Consultation Response from KC Highways Development Management		
2025/91531 Land off Leeds Road, Heckmondwike, WF16 9DB		
Demolition of existing semi-detached houses and associated buildings, and construction of 49 dwellings, including associated access and other associated works		
Date Responded: 19/05/26	Responding Officer: M Zenner	Responding Ref: K9-11NW/9

RECOMMENDATION: Whilst there are no objections in principle to residential development on the site, amendments and further information are required.

**Swept Path**

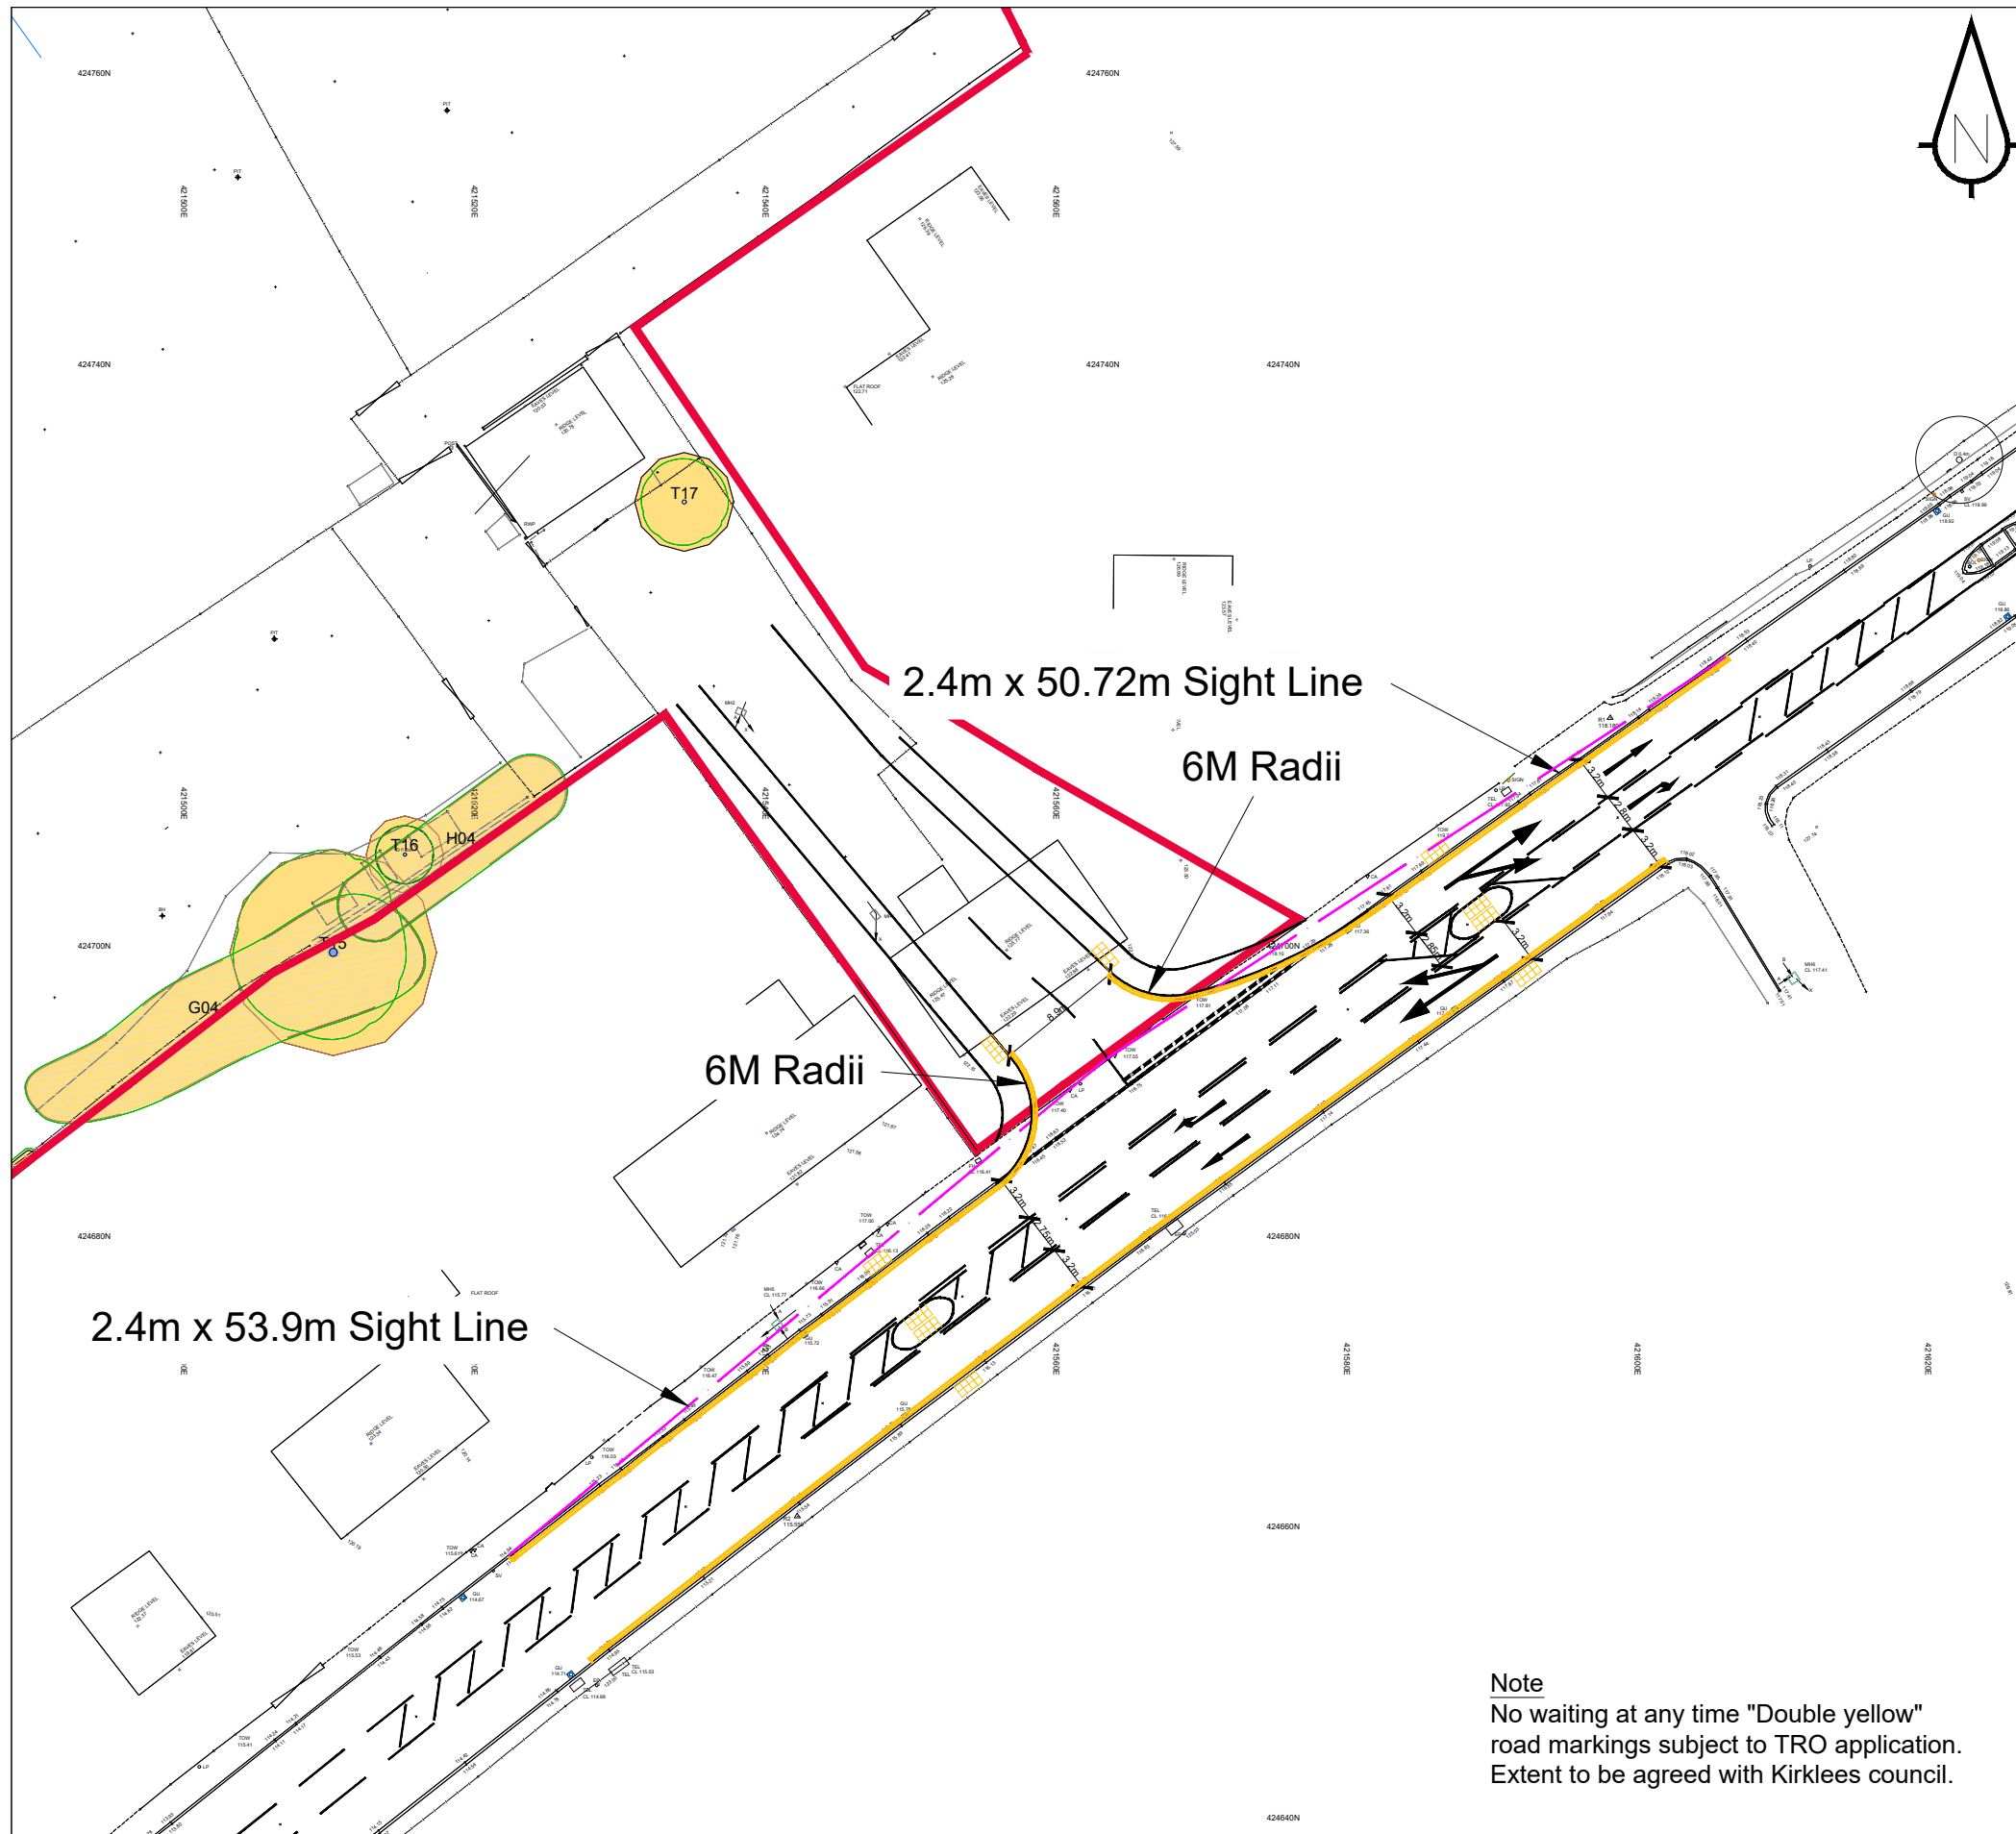
Swept paths should be undertaken to show that large vehicles (RCV/Fire Tender/ Pumping Station service vehicle) can negotiate the layout into the site and internally and through the lane widths proposed

including into the Alma Lane turning lane. The swept paths should also consider egress by vehicles from Stubley Farm Road in case tractors and trailers need to turn right out of the road.

HDM notes that in Appendix E of the Transport Statement swept paths are provided for a large refuse vehicle turning left into the site from Leeds Road and turning left out of the site onto Leeds Road. HDM is concerned that the 0.5m buffer is not provided and the left turn in seems to swing across the ghost island and encroaches into the exit lane from the proposed site access. HDM would recommend that the kerbline / carriageway alignment on the south side of the junction is amended and widened to address these issues.

Whilst the first cul-de-sac is provided with a turning head, the swept path for a RCV is exceptionally tight and isn't provided with the tolerances required. Furthermore, the visitor parking spaces proposed do not appear to have the required footway width alongside them.

The other two cul-de-sacs only provide turning areas suitable for a 4.6t light van which is not acceptable as they both exceed 20m in length. HDM is also concerned that the proposed 1.8m high wall with fence panels around the garden of Plot 24 will impede visibility from the turning area provided.

As noted above the Transport Statement has provided some swept paths, however, HDM require a swept path analysis for an 11.85m in length refuse vehicle indicating how it can pass an on-coming or parked family car throughout the site layout. The carriageway will require widening on the bends to enable this manoeuvre. There appears to be insufficient turning areas in the cul-de-sacs for refuse vehicles to turn around at the end of the cul-de-sacs.

### Vehicle Tracking Assessment

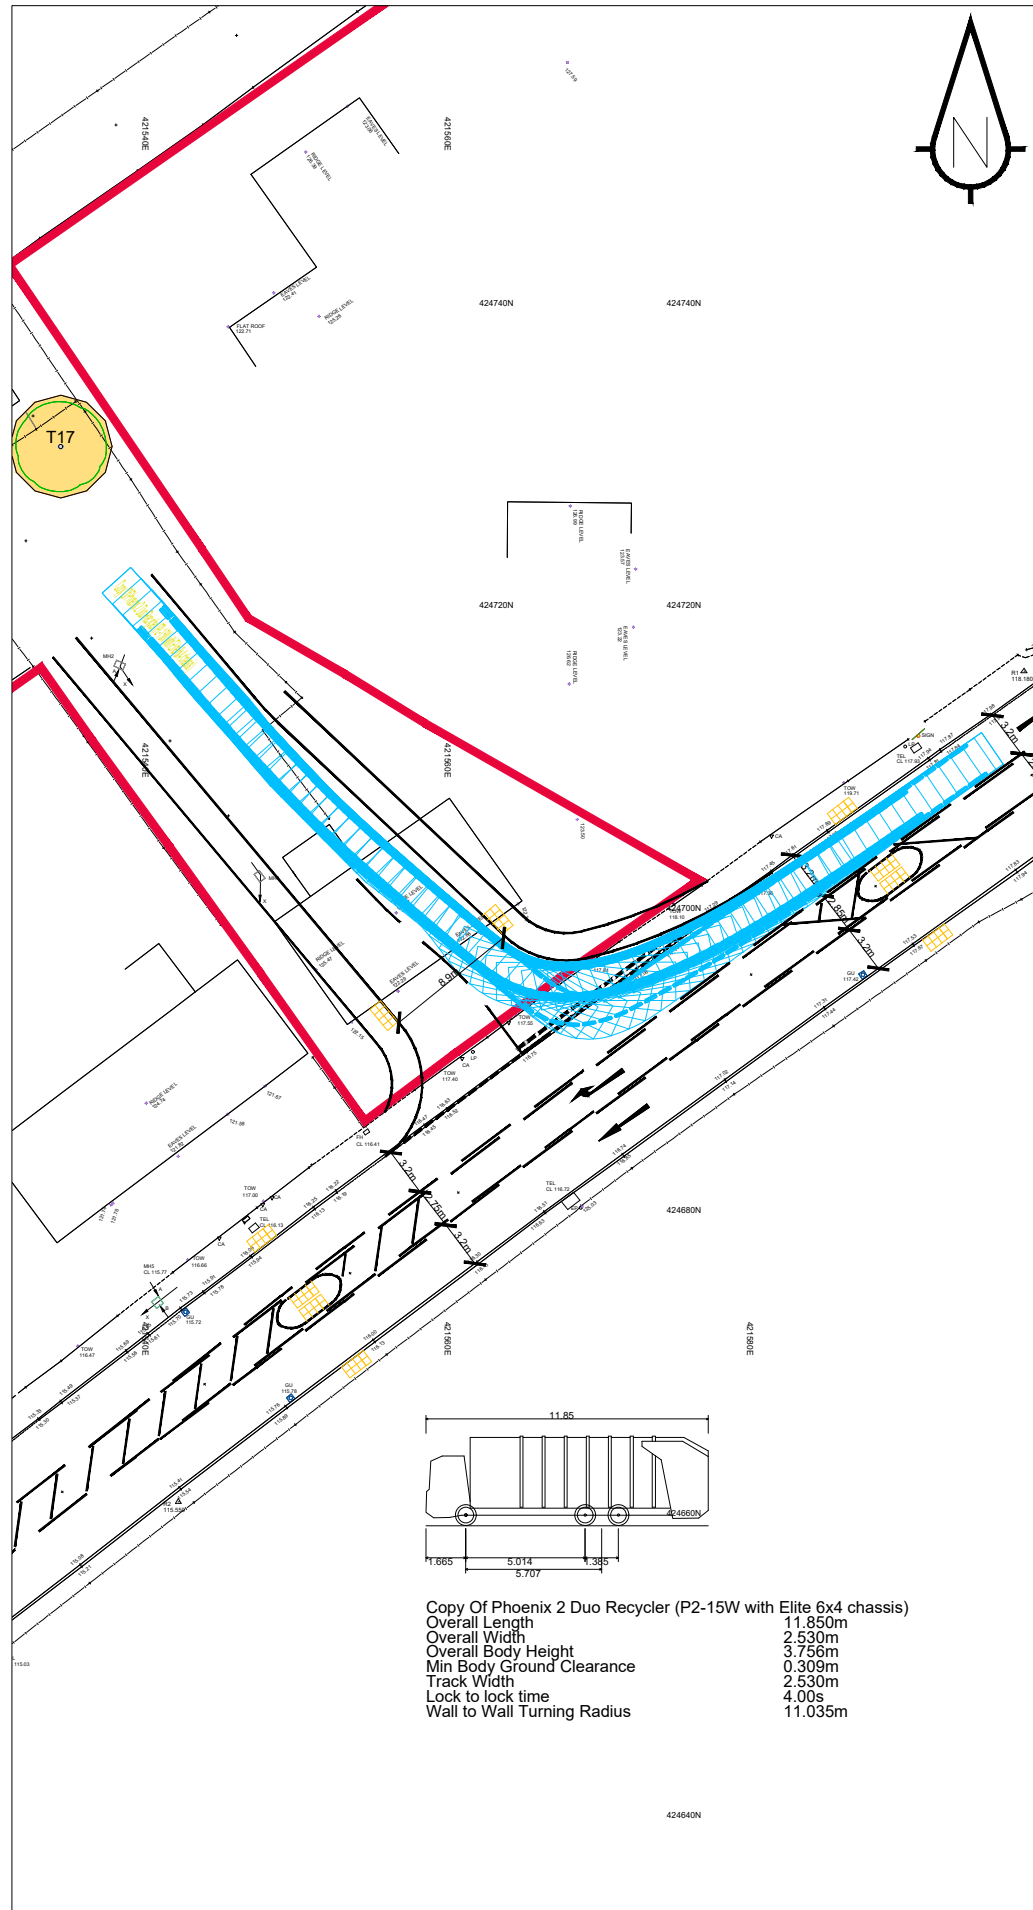
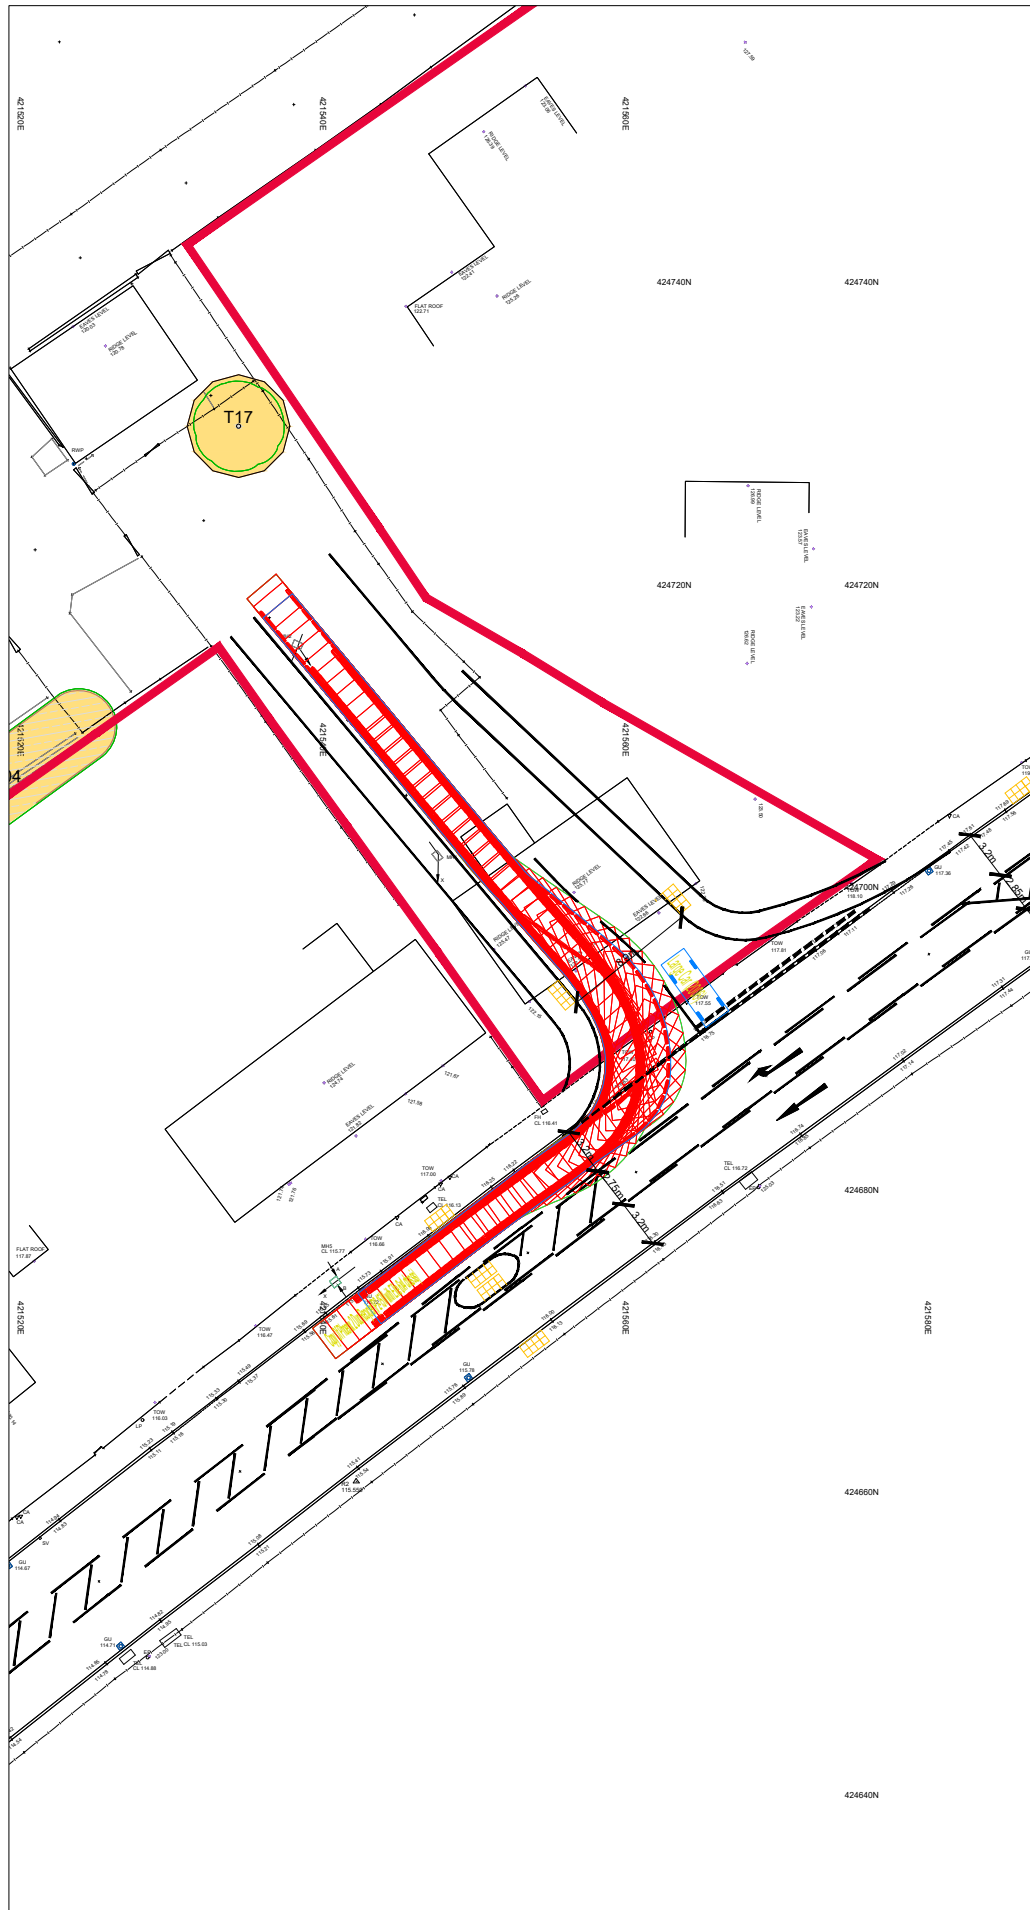
HDM is concerned that the three shared surface (Type C) streets proposed are longer than 20m and do not provide adequate turning facilities for a Kirklees RCV. Swept paths are shown within the Transport Statement but scaleable plans are requested.

However, the three shared surface streets proposed within the site all exceed 20m length and therefore do not comply and should be provided with the required turning head to allow a Kirklees RCV to access. Furthermore, the shared surface street proposed that also houses a pumping station also requires access by a pumping appliance. Yorkshire Water have confirmed that they would expect the pump station to accommodate a 10.5m long by 2.5m wide tanker (4000 gallon). Therefore, swept paths should be provided to ensure this vehicle can access and egress the site safely.
